WEST SUSSEX COUNTY COUNCIL CONSULTATION

TO:	Arun District Council FAO: Simon Davis
FROM:	WSCC - Highways Authority
DATE:	27th October 2021
LOCATION:	The Chalet Littlehampton Road Worthing BN12 6PG
SUBJECT:	FG/163/21/PL Development compromising marine workshop & boatyard, martial arts gym (Class E) & storage container compound (Class B8) to replace former glasshouses. This site is a Departure from the Development Plan & is in CIL Zone 3 (Zero Rated) as other development.
DATE OF SITE VISIT:	Site and access known to officer
RECOMMENDATION:	Advice
S106 CONTRIBUTION TOTAL:

SITE PLAN 1:500 @ A3

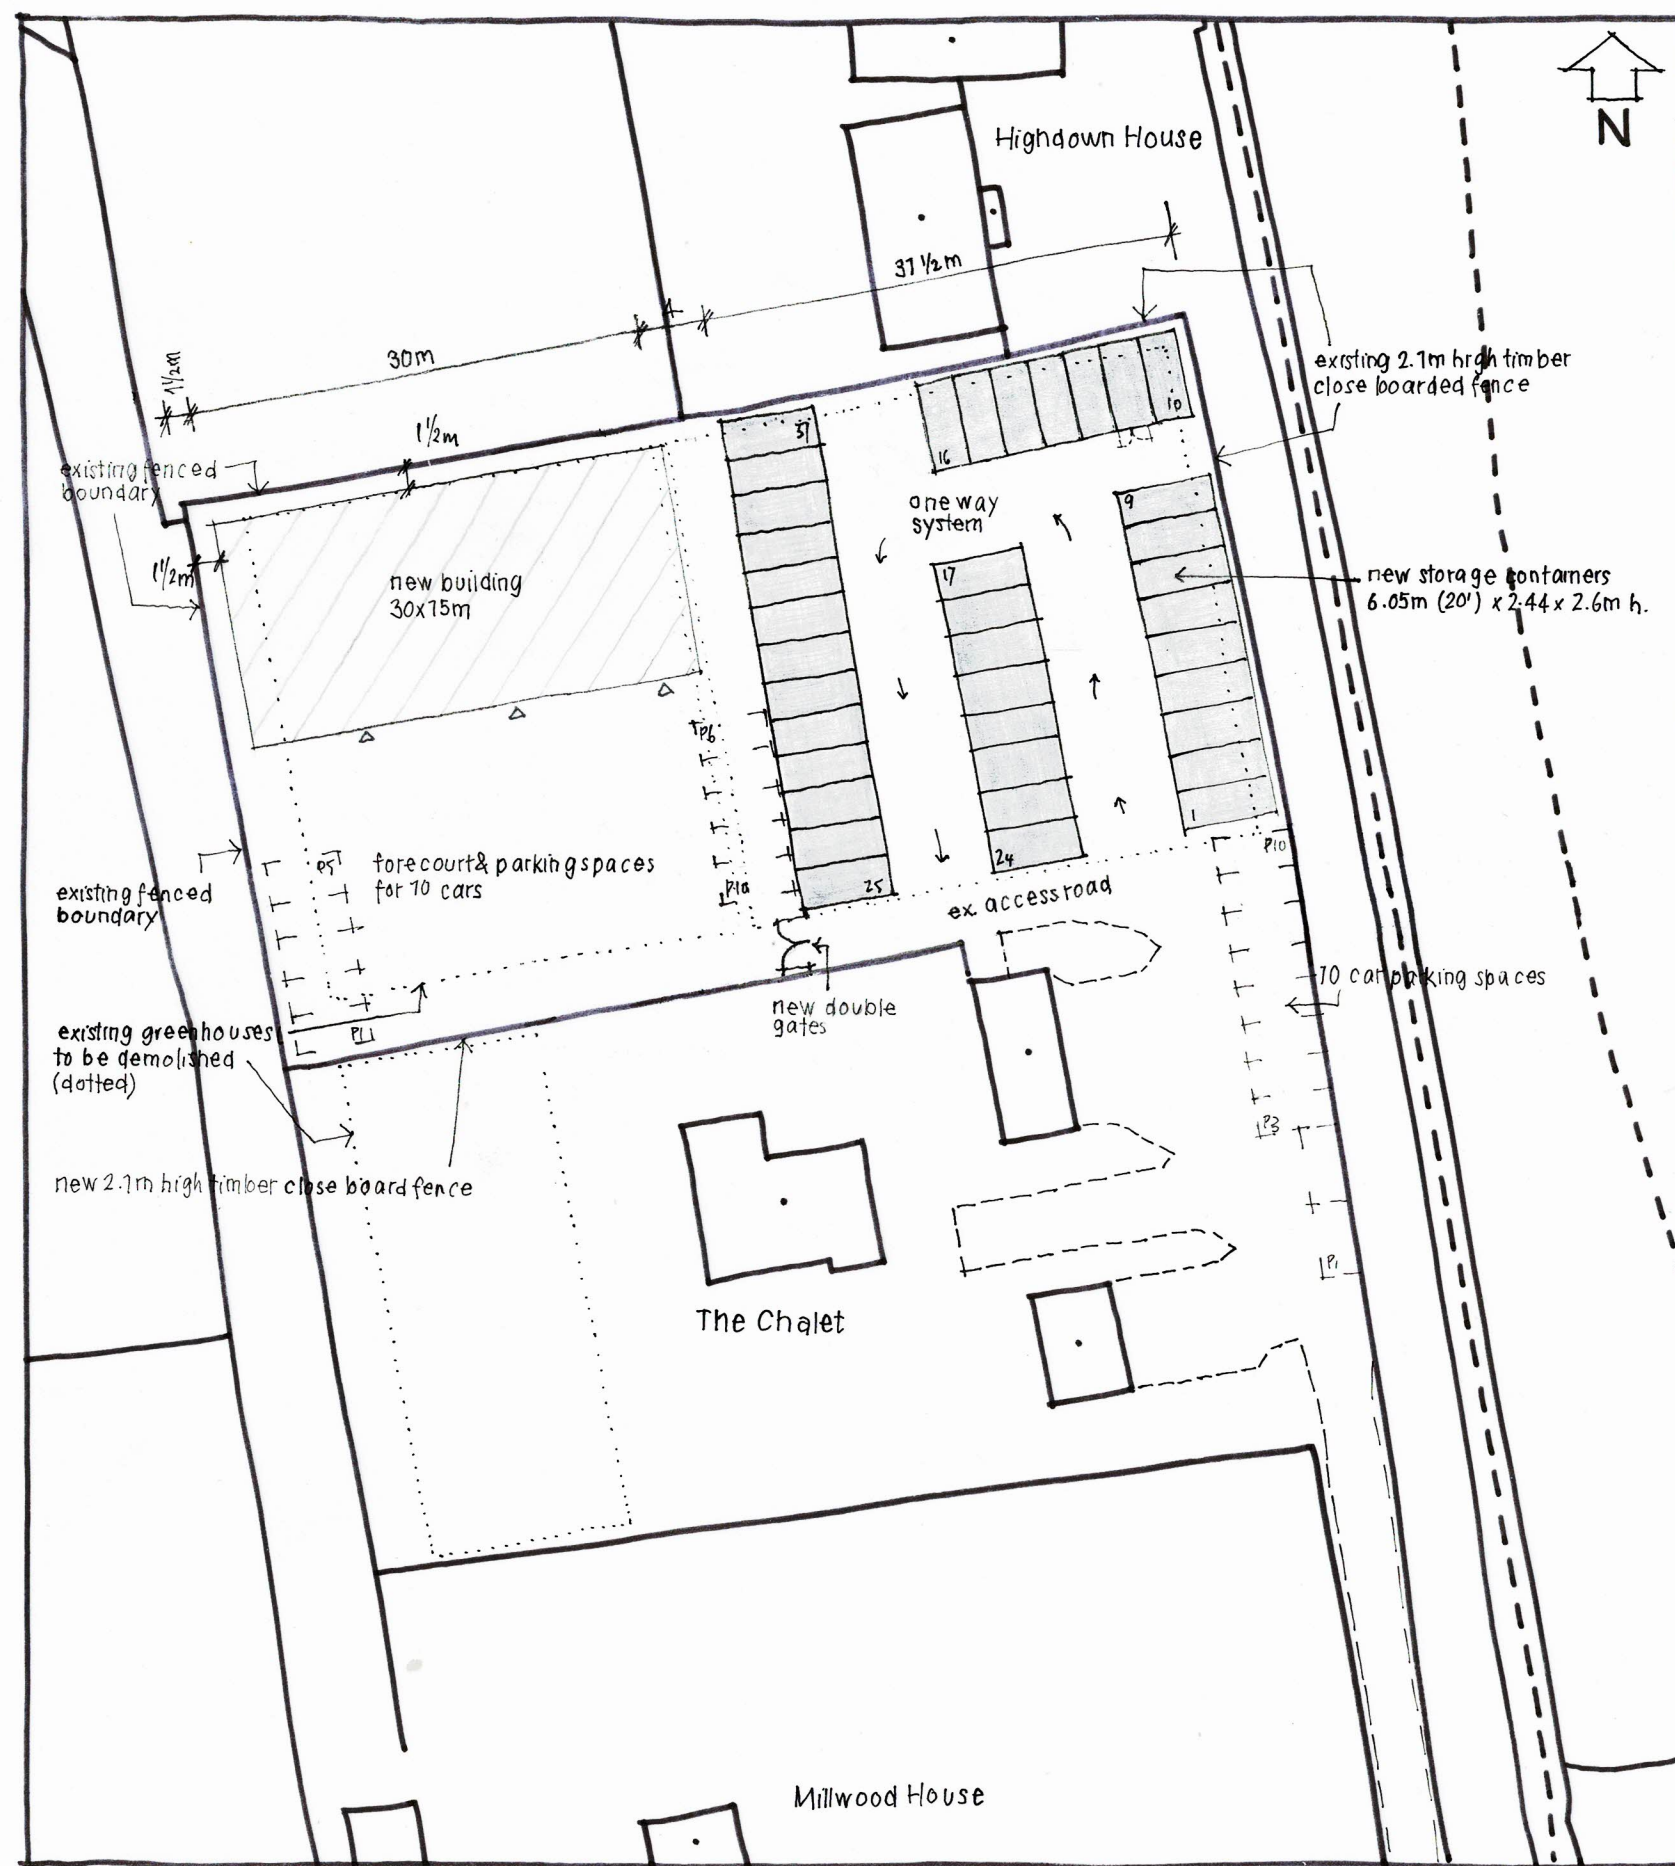
Access off the A259 is adequate in terms of visibility and there are no recorded accidents to indicate that this access or it's set up has or is causing a safety issue. The access entrance to the site and the private access road into the site is set back approximately 17m from the

edge of the A259 carriageway. This will allow space for vehicles to wait to pass off the A road, given the long access road into the site which can cater only for one-way movement before passing can occur within the site area. Given the sites proposed uses there is a higher chance of conflicting vehicle movements than compared with the previous use.
